**TOWER 2, LEVEL 23
DARLING PARK, 201 SUSSEX ST
SYDNEY NSW 2000**

RESPONSE TO SUBMISSIONS - OAKDALE SOUTH ESTATE - SECTION 96(2) (SSDA6917)

On 4 November 2016 an Environmental Impact Statement (EIS) and supporting documentation was submitted to the NSW Department of Planning and Environment (DPE). The EIS related to a Section 96(2) Modification Application regarding an approved State Significant Development Application (SSDA 6917). This Section 96(2) modification application, known as SSDA 6917 MOD 1, seeks approval for revisions to the approved Master Plan and Stage 1 Development in the southern portion of the estate.

Section AA (Southern Boundary)
1:200 (Adapted from Civil section)

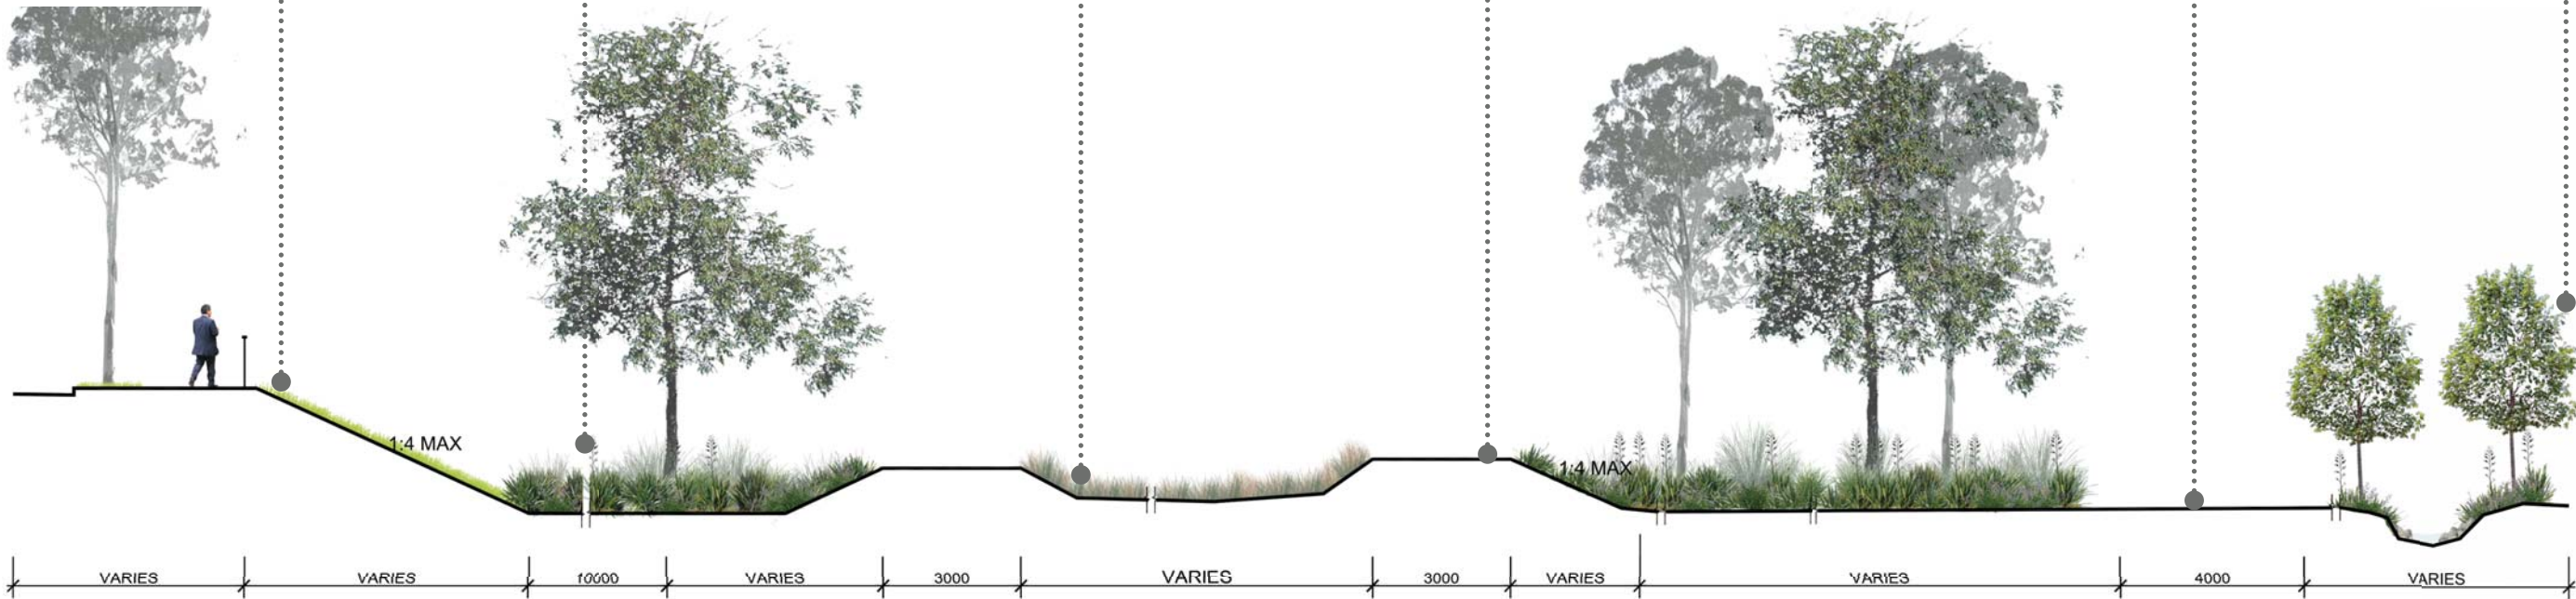
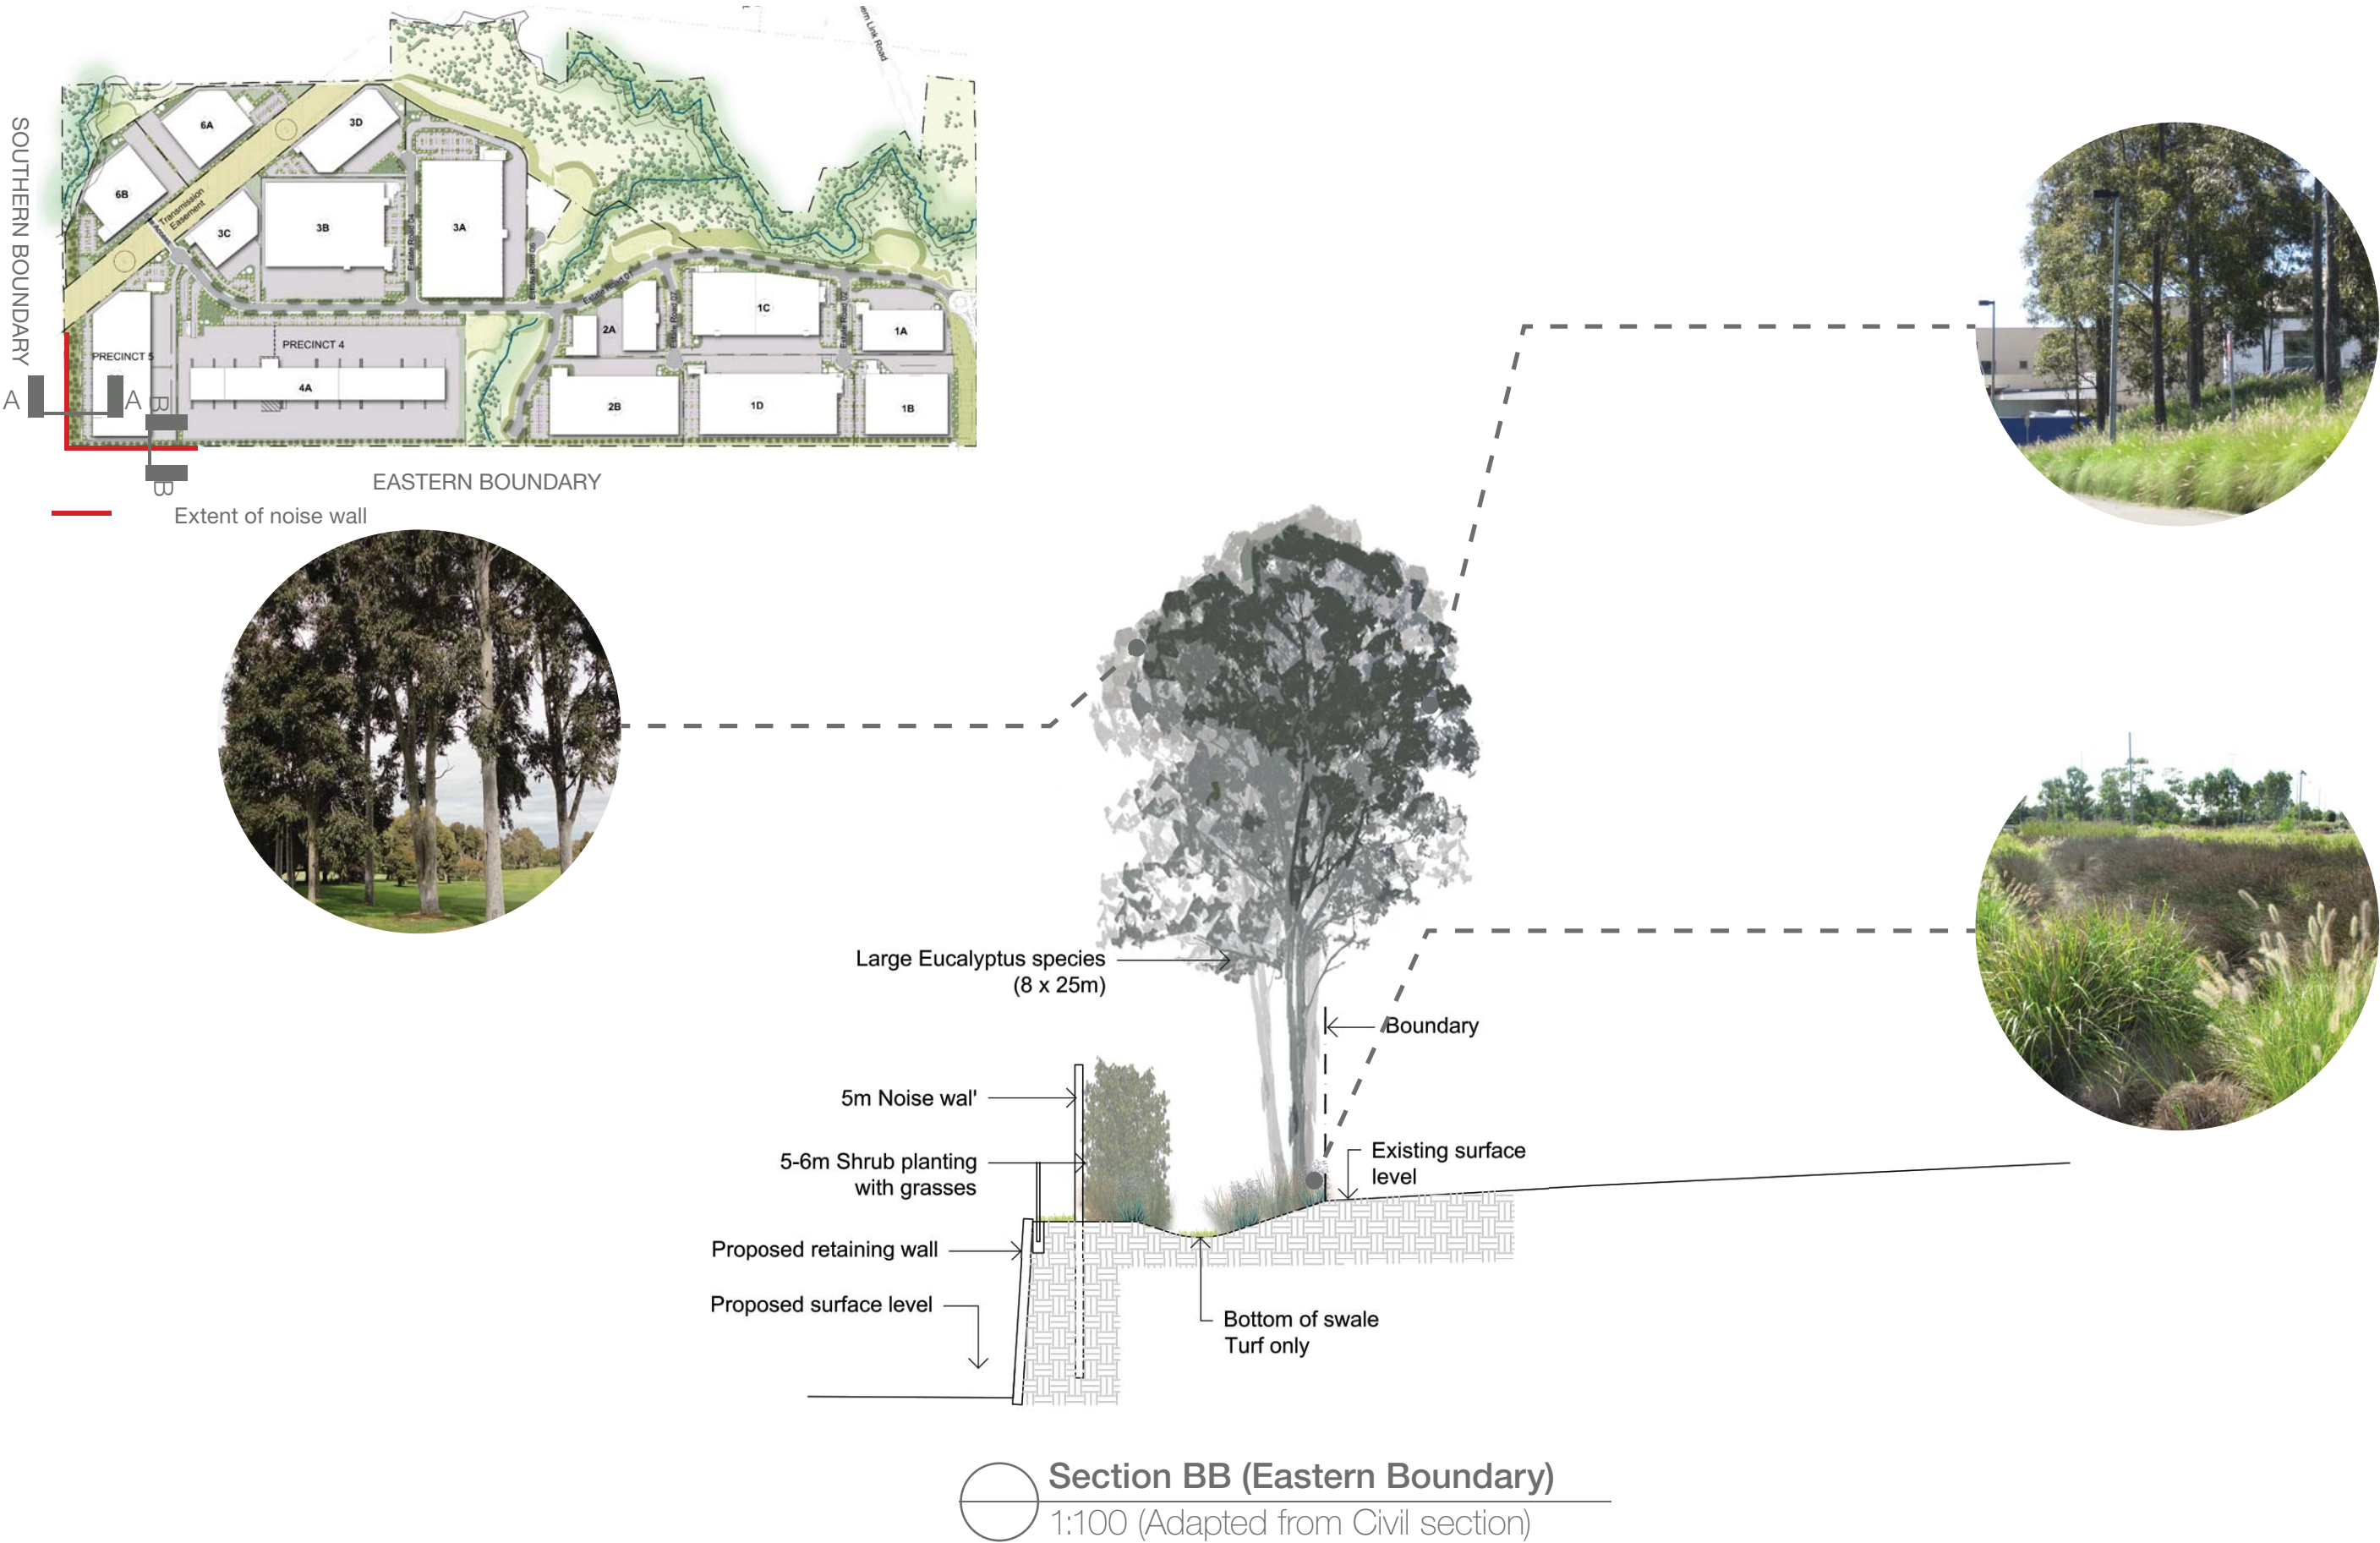
MATTERS RAISED	APPLICANT RESPONSE
	Detail of the layout and hardstand areas are addressed in the Sigma and Toyota applications and subsequent RTS documents.
Landscape Buffer <i>Given the likely building layouts for Precincts 4 and 5 as well as the extended noise wall required, it is considered that the 30 m setback with 5 m high landscaped mound should also be provided along the eastern boundary where the site directly adjoins the RU4 zoned 'Jacfin rural-residential' land. This will ensure that the noise wall and new industrial buildings will be adequately screened from view of the rural-residential allotments which will increase their future amenity.</i>	A 30m setback is not appropriate or necessary along the eastern boundary adjoining the RU4 zoned land. The sloping nature of the topography from the RU4 land down to the Goodman site as well as the proposed 10m landscaping setback and 5m noise wall is sufficient to provide adequate visual and acoustic buffering between the sites. Adequacy of this acoustic treatment has been assessed in the Noise Impact Assessment. The approved landscaping setback includes a range of planting heights and a range of landscaping management measures have also been committed to by the application to ensure the landscaping becomes well established and serves as an effective visual screen. The proposed landscape treatment within the 10m setback a consists of a mixture of native groundcovers, shrubs and trees. Trees proposed include <i>Eucalyptus moluccana</i>, <i>Eucalyptus tereticornus</i> and <i>Eucalyptus cebra</i>. This tree combination shall be planted in groups and consist of mature heights from 15-30 metres and canopy width of 8- 15. Providing a substantial visual screen, planted in these groups or 'copses', akin to natural growth habits. The mid 'layer' of shrubs shall consist of <i>Acmena smithii</i> 'Minor', a native lily pili, growing to approx. 5-6 metres. These shrubs shall be planted in groups

MATTERS RAISED	APPLICANT RESPONSE
Landscape and Civil Plans <i>The Landscape Plans and Civil Works Package should be updated to include the extended noise wall.</i>	As noted in the submission prepared on behalf of Jacfin Pty Ltd, discussion between Jacfin and Goodman has confirmed that the construction of the noise wall is part of the scope of works to be undertaken by Goodman. The Landscape Plans, and Civil Works Package have been updated to include the extended noise wall along the eastern boundary of the OSE. These amended plans have been submitted with this RTS.
Local Road Connection <i>The conditions of consent for the Modification Application should require the continuation and dedication of the road reserve for Local Road 03 to the boundary of Lot A and the Department should require Goodman to provide updated plans with the centre line of Estate Road 03 relocated 17.5 metres to the north to align with the approved location of Local Road 1 on Lot A.</i>	The Local Road 03 alignment has been retained at the same location on the eastern boundary as the approved development. The location is based on detailed constraints analysis which have informed the improved design. Should Jacfin wish to co-ordinate the centreline of the road with their estate road works they may consider shifting their Estate road 17.5 m south as part of a development application for works in this part of their estate (which is currently subject to concept approval only). A small portion of development land will remain between the proposed Road 03 and the eastern boundary. Whilst the alignment of Road 03 protects the opportunity for a future connection to this application adjoining land, this application does not seek approval for a connection. The traffic modelling of the OSE road network is based on OSE traffic only.

MATTERS RAISED	APPLICANT RESPONSE
	and alternate, from the front to the back of the setback, creating a mid- height screen. This planting shall also directly screen the acoustic wall proposed. Finally, Pennisetum ‘Nafray’ shall be planted at the base, and complement the tree and shrub plants by providing a 60cm tall understory throughout this setback. The 10m landscape setback to the eastern boundary is already 5m greater than the DCP control. The approximate height that the OSE is set down from existing levels by approximately 3.5-7.5m. Furthermore, the Assessment Report accompanying the Jacfin land rezoning approval included the following statement: <i>“An important consideration is that the rural residential proposal does not impact on the industrial activities owned and operated by others to the north and west. This is a key reason why the two hectare minimum lot size is needed.”</i> It should be noted that Industrial employment land use is the priority for the precinct, with RU4 uses only recently approved to operate as a <i>“buffer use to solve an existing land use conflict”</i>. The Assessment report also included the following statements <i>“While it is acknowledged that new landowners moving into the interface area are likely to do so with the knowledge of adjoining industrial land uses, the Department considers that the number of potential new dwellings should be limited to ensure that future land use conflicts are not created ...”</i>
